STATE OF NORTH CAROLINA
DEPARTMENT OF TRANSPORTATION

Addendum No. 1

RE: Contract ID: C202446

US-264 From The Pavement Joint East Of NC-58 To
The Greene County Line

## SUMMARY OF QUANTITIES

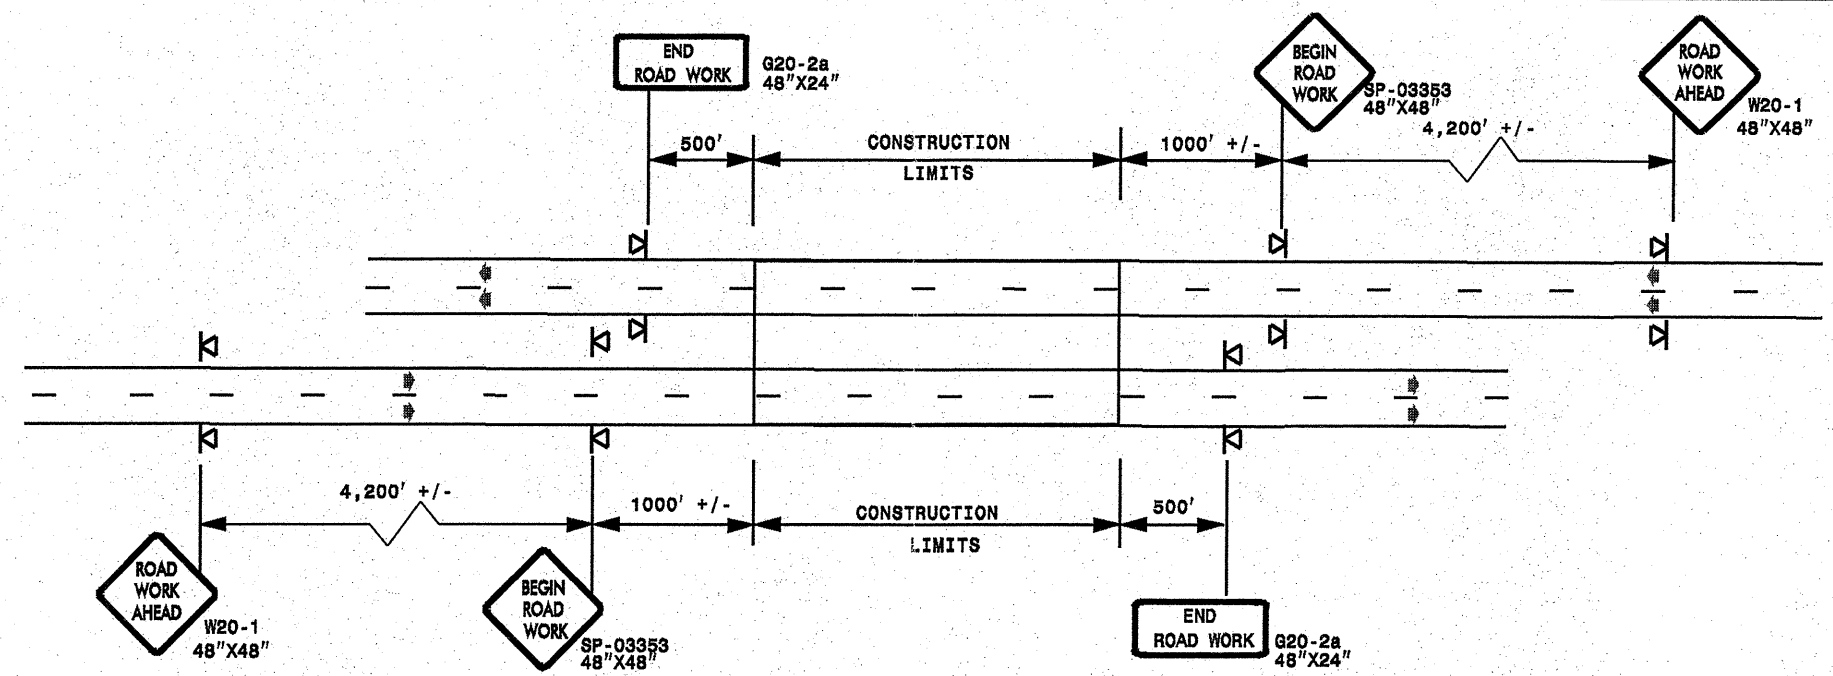
On Sheet No. 3 the Summary of Quantities has been revised to add a column for Seeding and Mulching.

On Page No. 2 of the item sheets by copy of this addendum the following pay item is hereby added:

<u>Item</u>	<u>Description</u>	<u>Quantity</u>
22-6084000000-E- 1660	Seeding and Mulching	20 ACR
